CITY OF ALBUQUERQUE

July 11, 2019

Re: Burger King
Project Address
Traffic Circulation Layout
Engineer's/Architect's Stamp ??-??-?? (B10D003C3)

SHEET TITLE: SITE PLAN

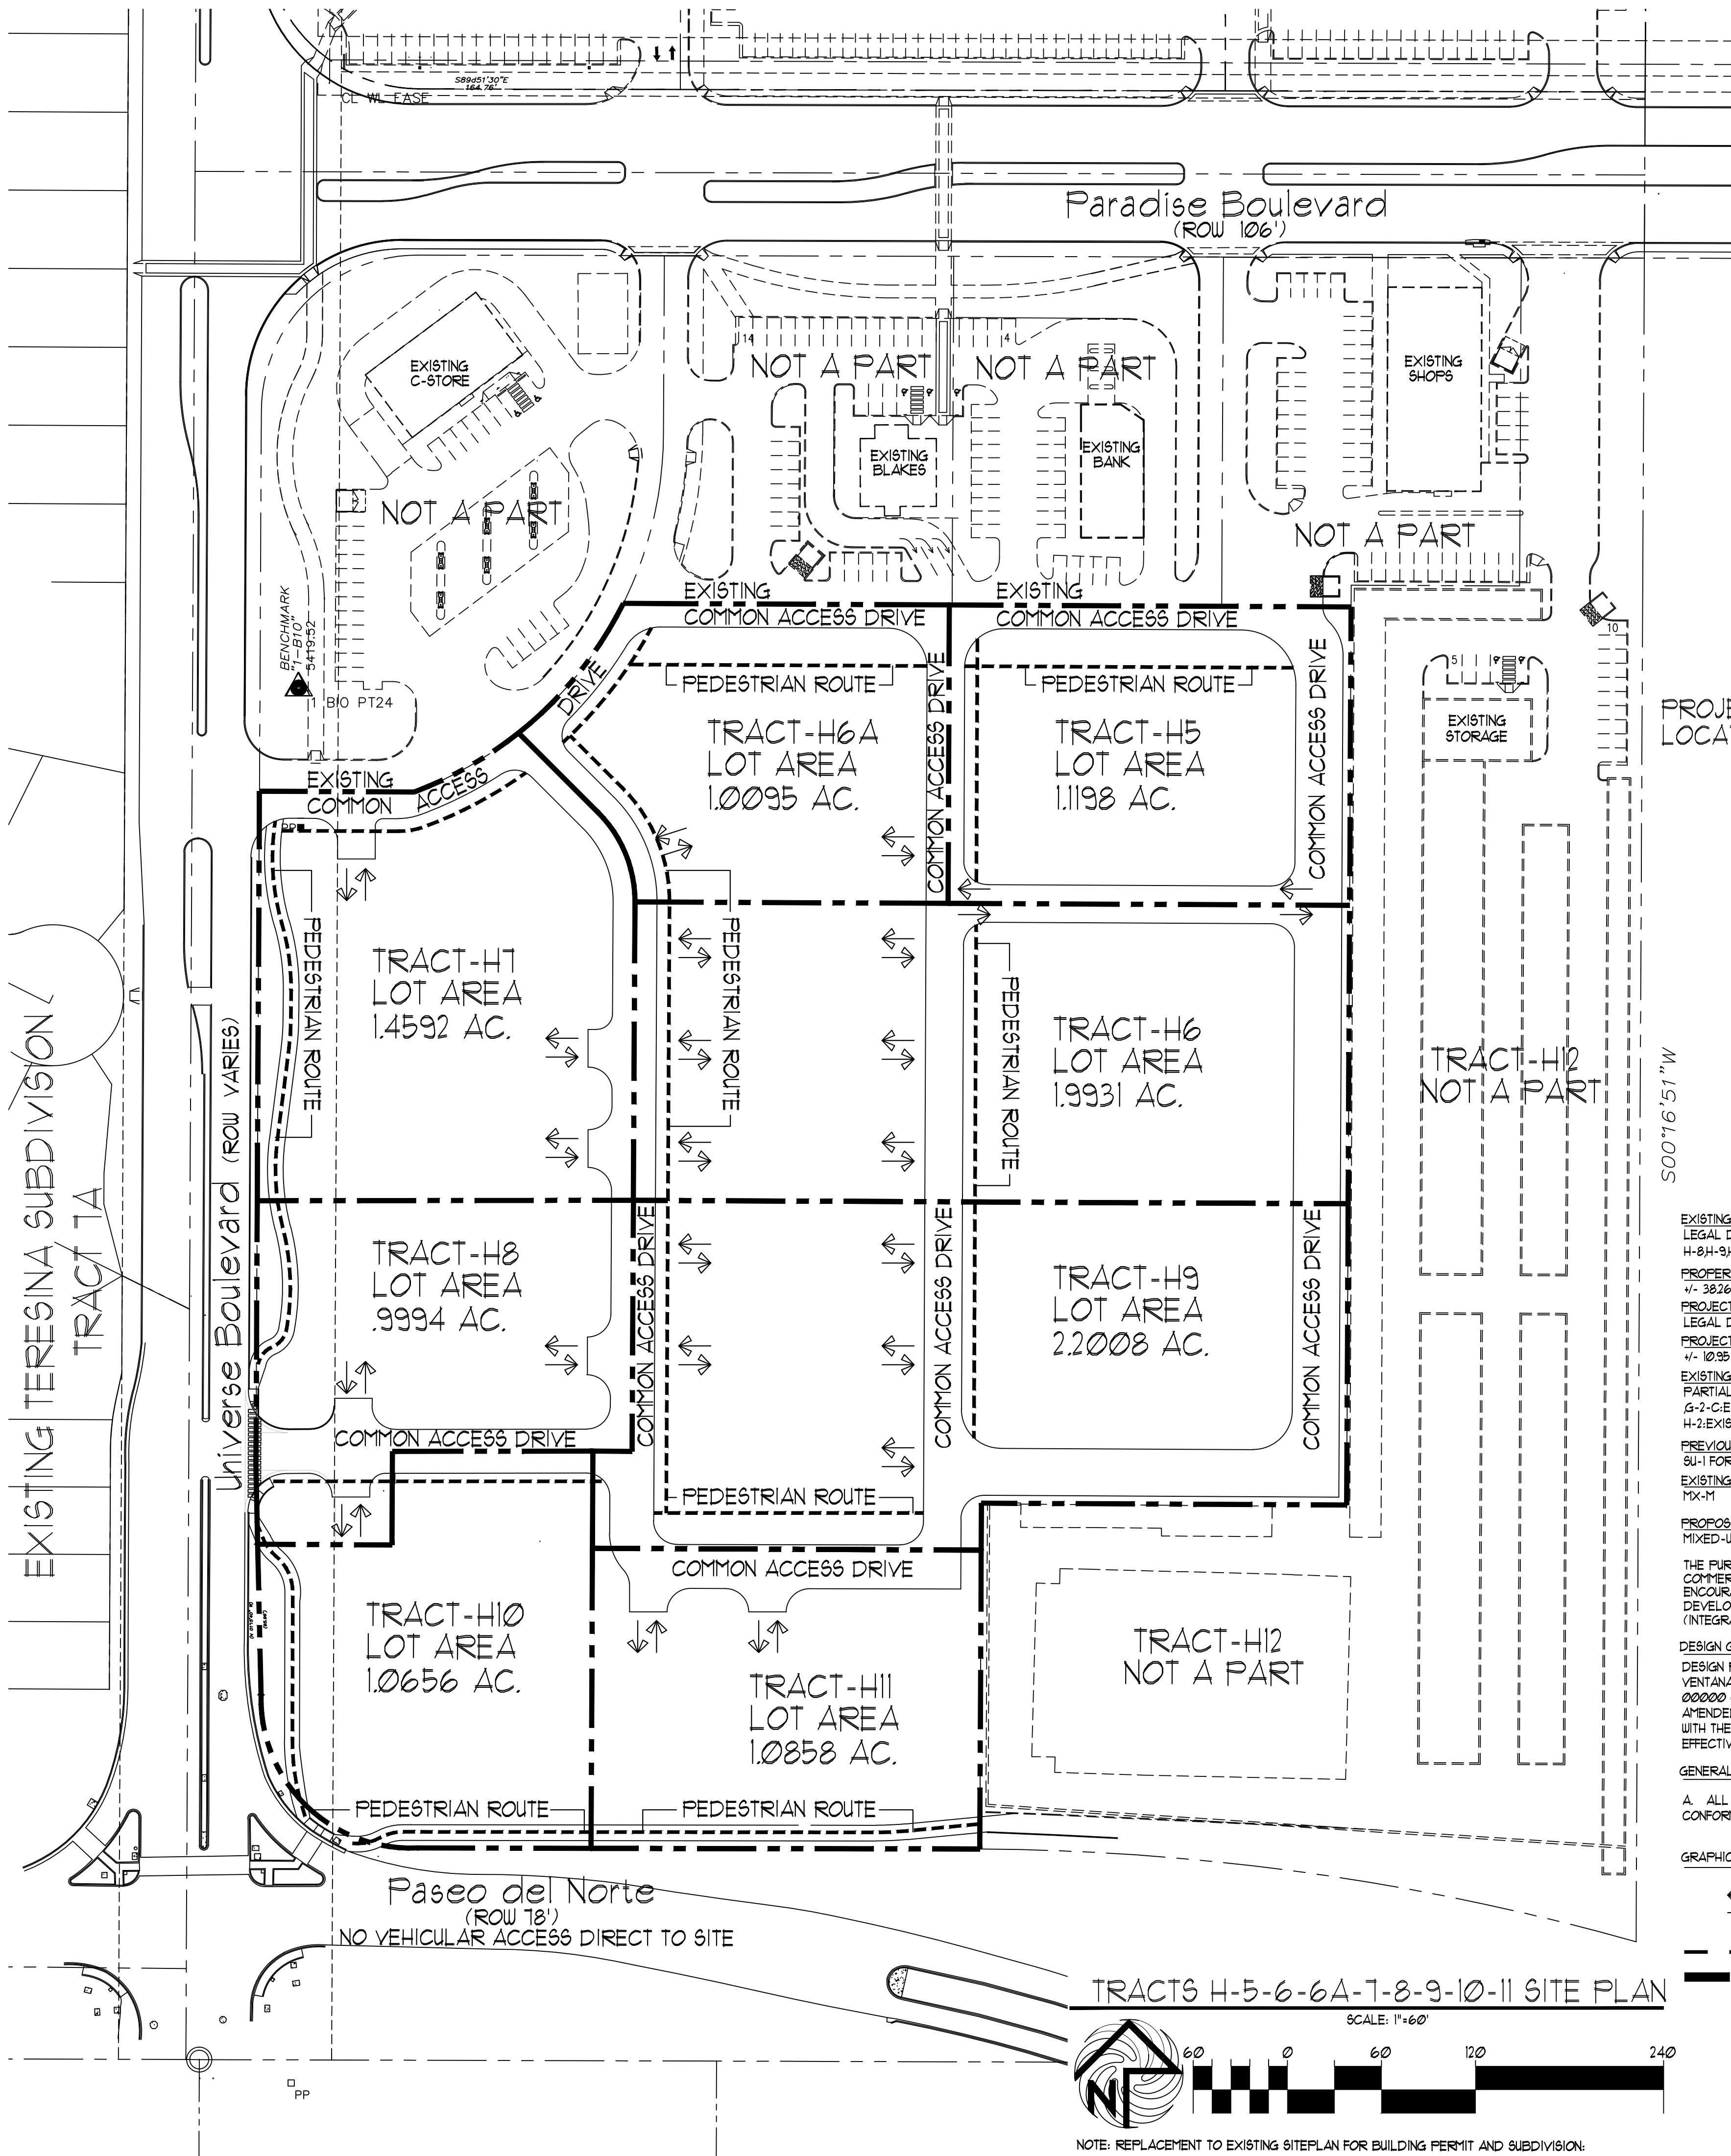
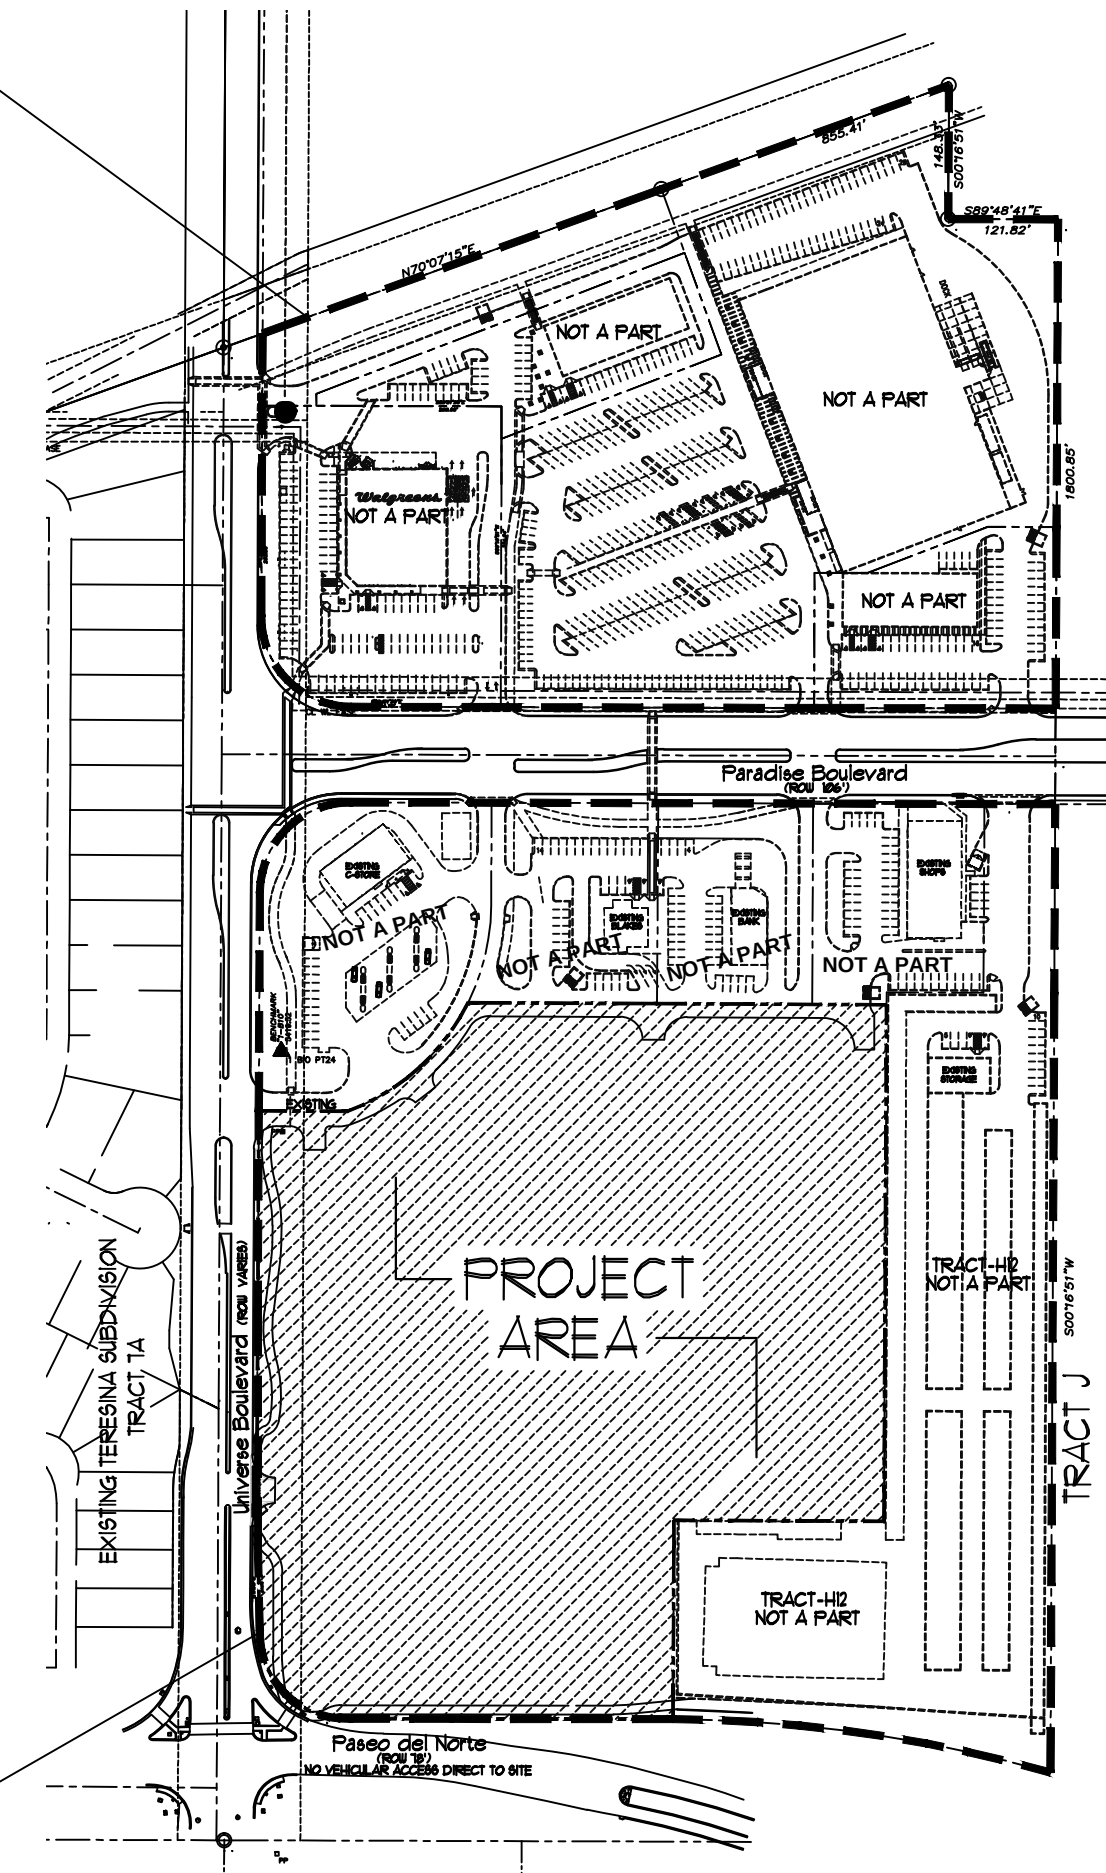
1. If you have not attended PRT, you will need to attend one for this project.
2. This project should go through DRB. The process for this project is siteplan DRB.
3. Clarify if this project is a part of a sitedevelopment. If so, please provide the overall site development plan.
4. Sidewalks are required along all frontages.
5. Pavement and curb and gutter is required along Paseo del Norte.
6. Provide a copy of refuse approval.
7. Dedication is needed along Paaseo Del Norte Blvd due to widening of Paseo.
8. Work within the public right of way requires a work order with DRC approved plans.
9. Please add a note on the plan stating "All improvements located in the Right of Way must be included on the work order."
